**BUILDING CODE OF AUSTRALIA CAPABILITY STATEMENT – Rev C**

Property: The Ribbon - 31 Wheat Road Sydney

The purpose of this submission is to advise that we have undertaken a preliminary assessment of the revised architectural drawings titled "The Ribbon, Redevelopment of 31 Wheat Road Drawing," prepared for Sydney Harbour Foreshore Authority received on the 23 July 2013 by Hassell [ARC-HSL-DA1000(A), ARC-HSL-DA1052(A), ARC-HSL-DA1060(-), ARC-HSL-DA1080(A), ARC-HSL-DA1090(A), ARC-HSL-DA1091(A), ARC-HSL-DA1100(A), ARC-HSL-DA1101(A) to ARC-HSL-DA1113(A), ARC-HSL-DA1150(A) to ARC-HSL-DA1154(A), ARC-HSL-DA1200(A) to ARC-HSL-DA1204(A), ARC-HSL-DA1350(A), ARC-HSL-DA1930(A), ARC-HSL-DA1950(A), ARC-HSL-DA1951(A) & ARC-HSL-DA1952(A), against the provisions of the Building Code of Australia 2013 ("BCA") as per the requirements under Clause 145 of the Environmental Planning & Assessment Regulations 2000 ("EP&A Regs).

DRAWING TITLE  
**GA PLANS - OFFICE L03 AND L04**

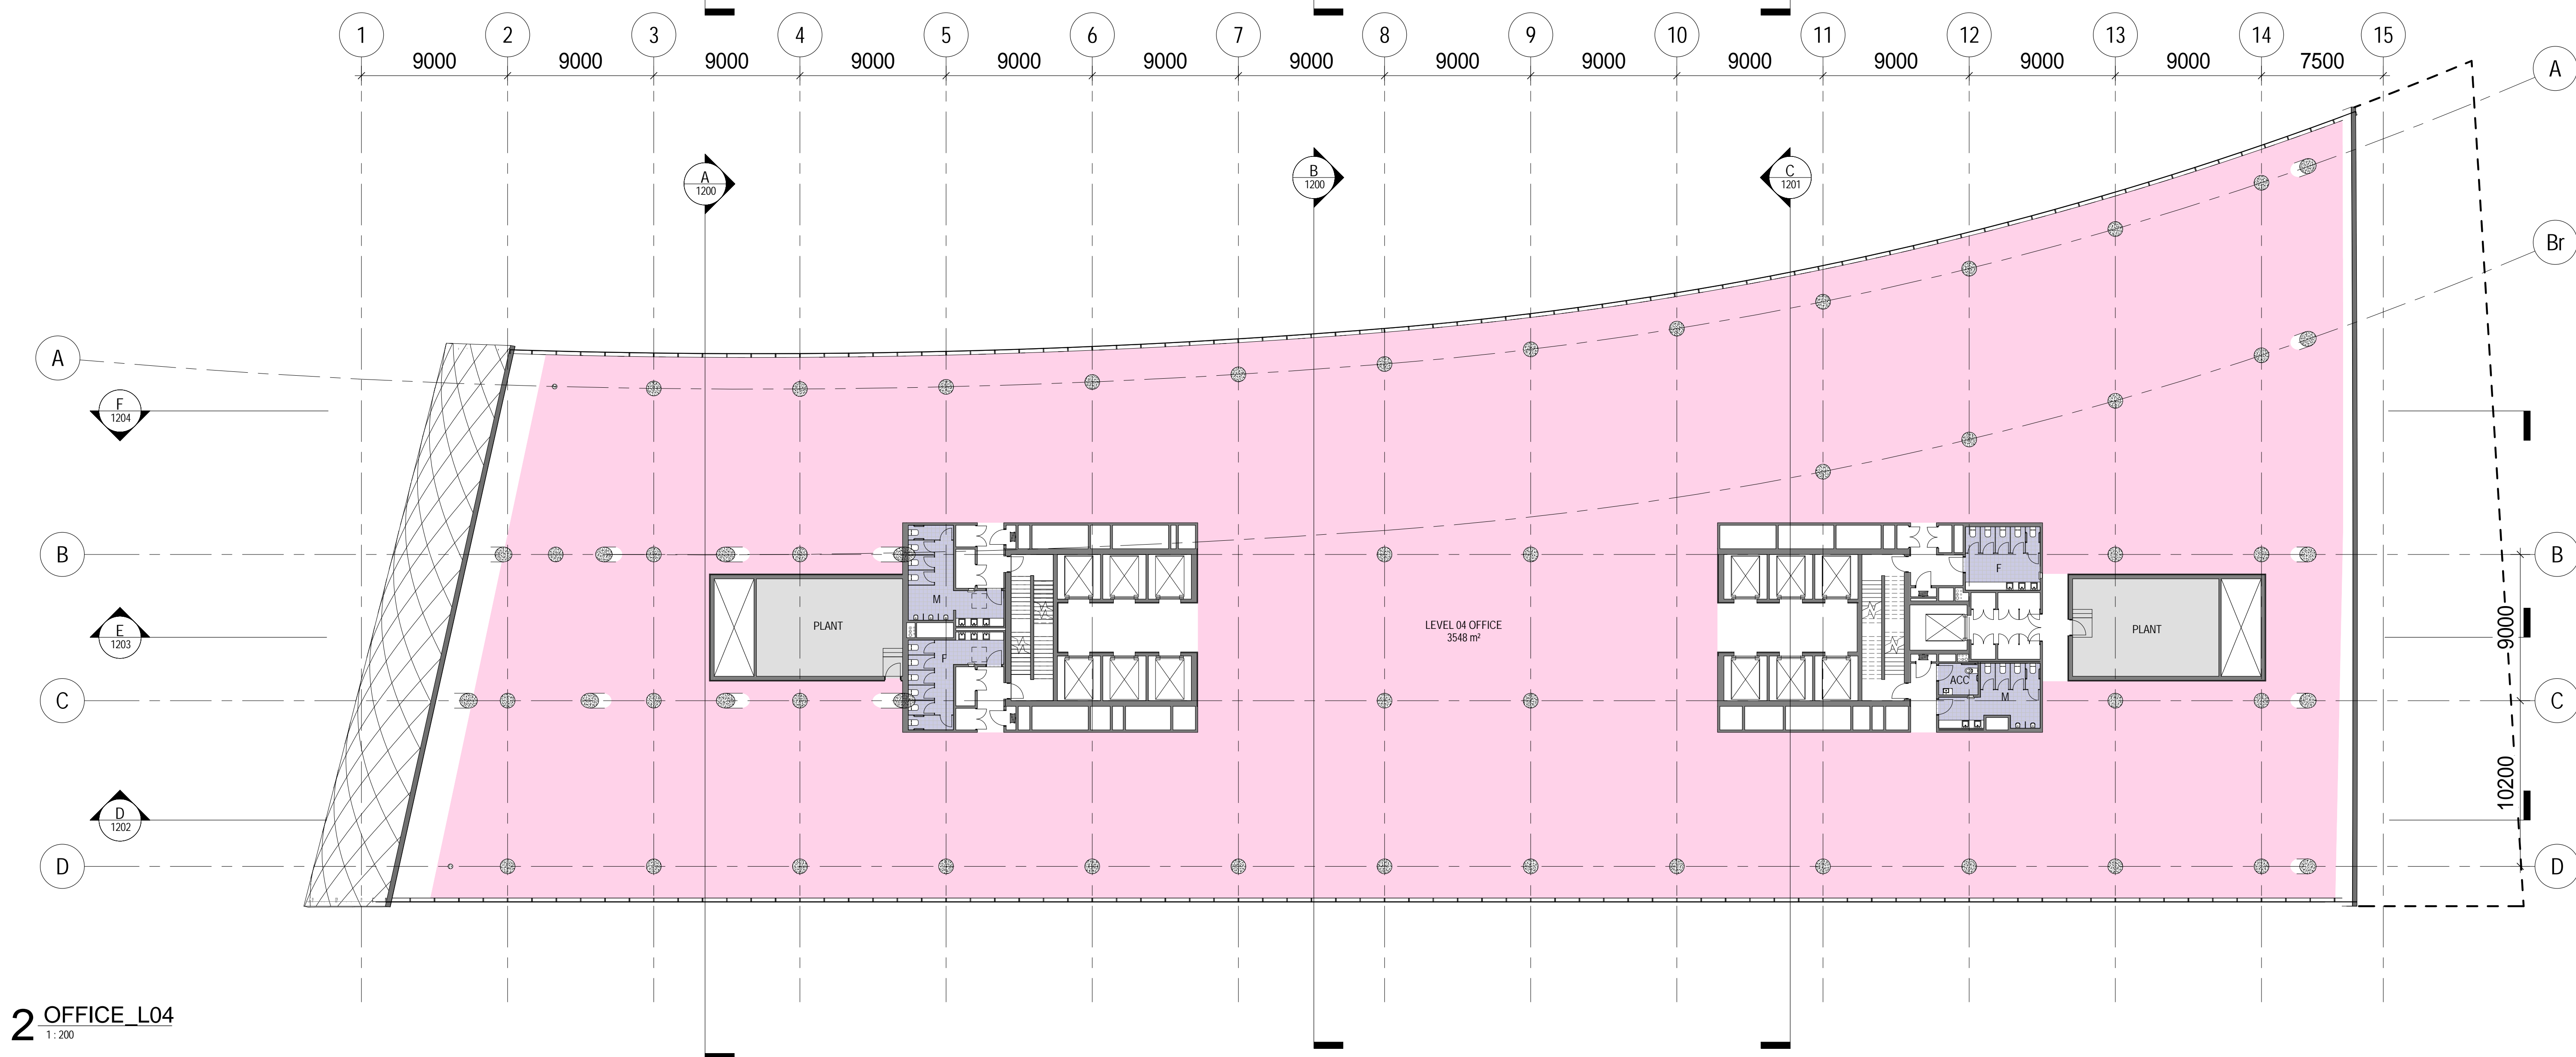
- Re-orientation of the fire hose reel cupboard as to prevent the cupboard door from obstructed access to the fire isolated exits, on the lower podium, lower office floors and Level 15.

DRAWING TITLE
GA PLANS - OFFICE L15 AND PLANT MEZZANINE

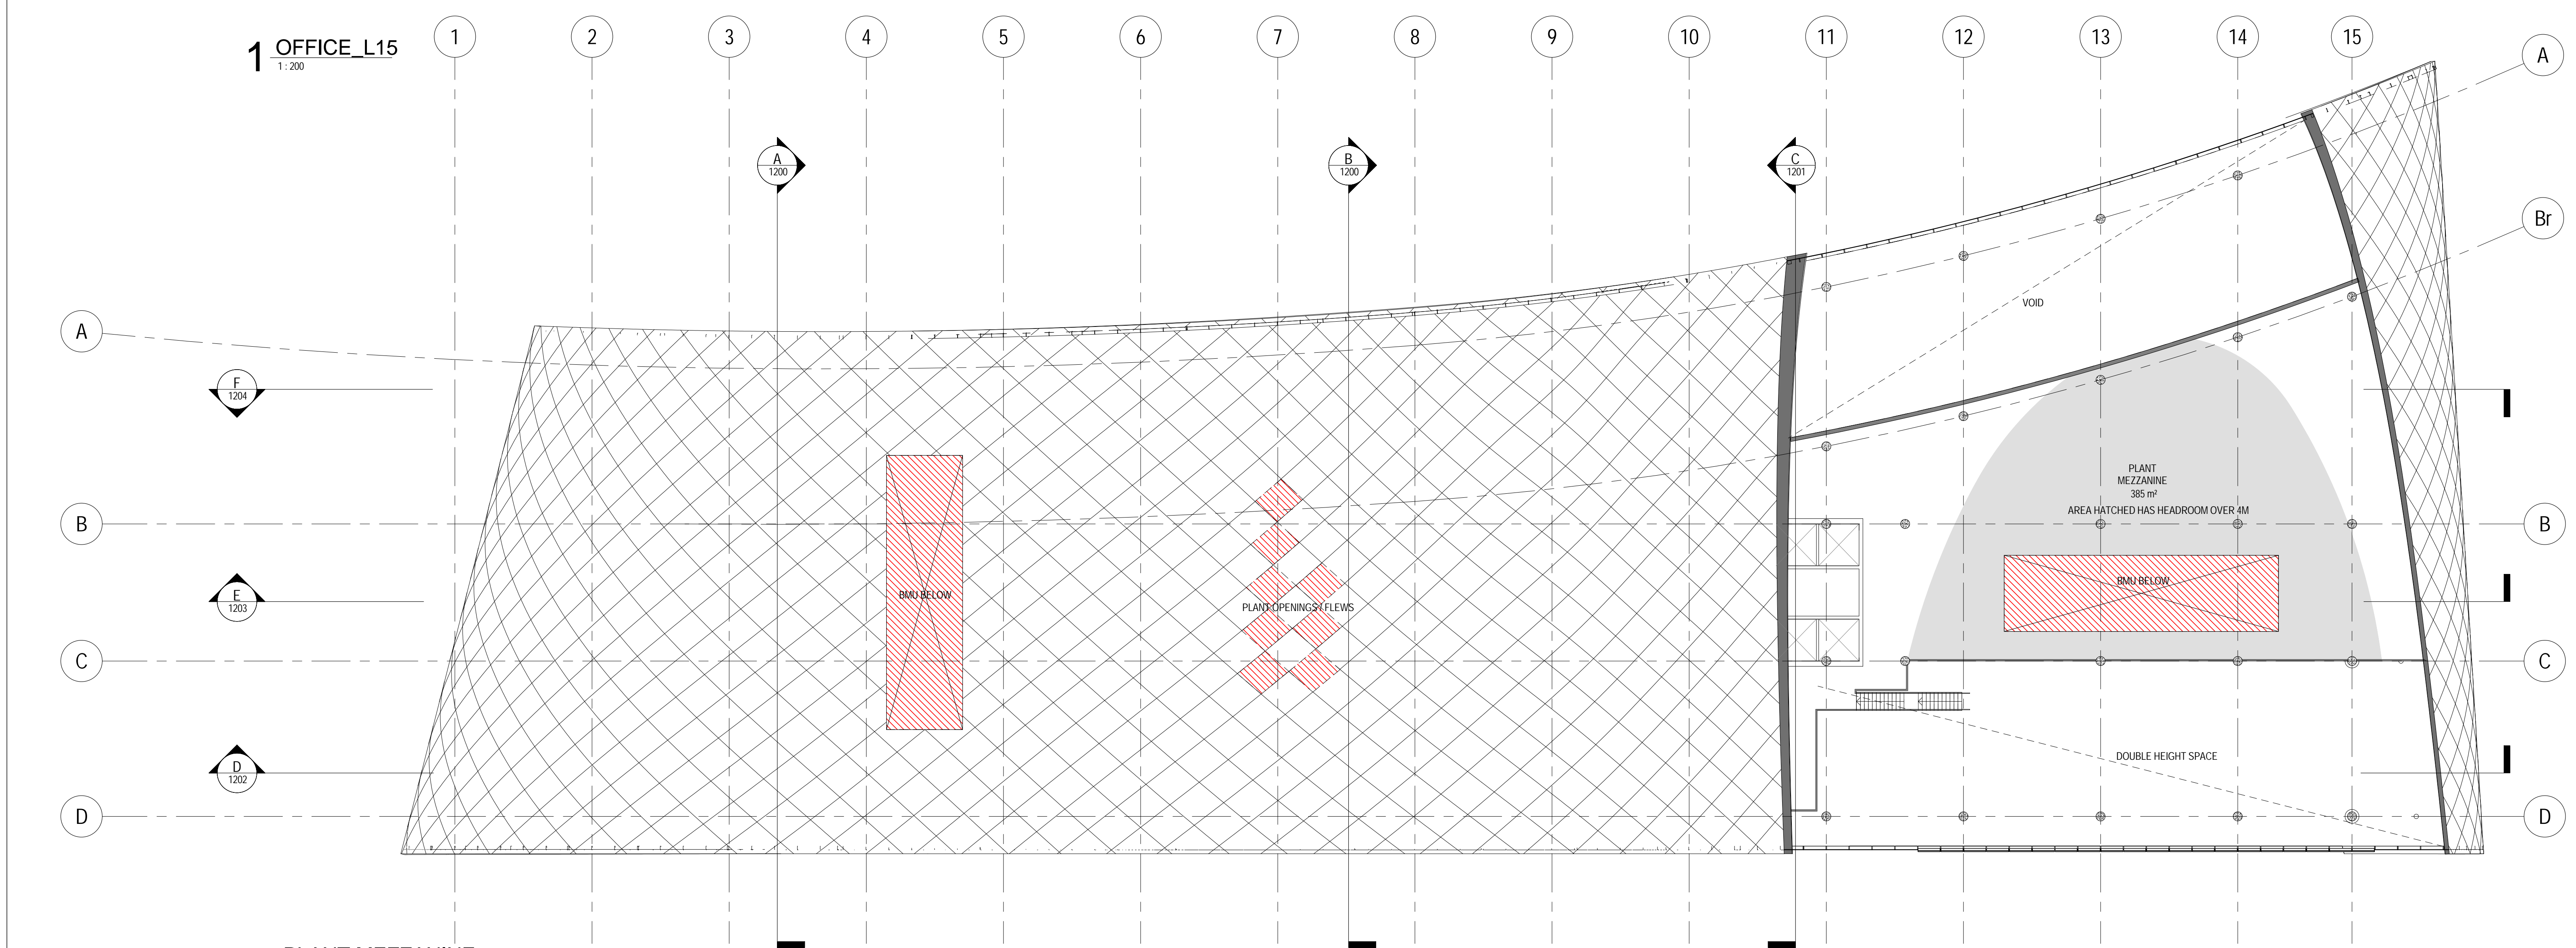
- Level 15 & Roof Plant Room *exits* rationalisation, i.e.:
  - Access to only one *exit* serving level 15 office where two would normally be required;
  - Access to only one legitimate exit from Level 15 Plant where two would normally be required, note that the illustrated second path via the Level 15 office tenancy is not permissible.

- No direct access to any fire isolated exit where a minimum of two would normally be required. Note that the Plant Mezzanine level is a BCA defined *storey*.

- Related travel distances concerns.
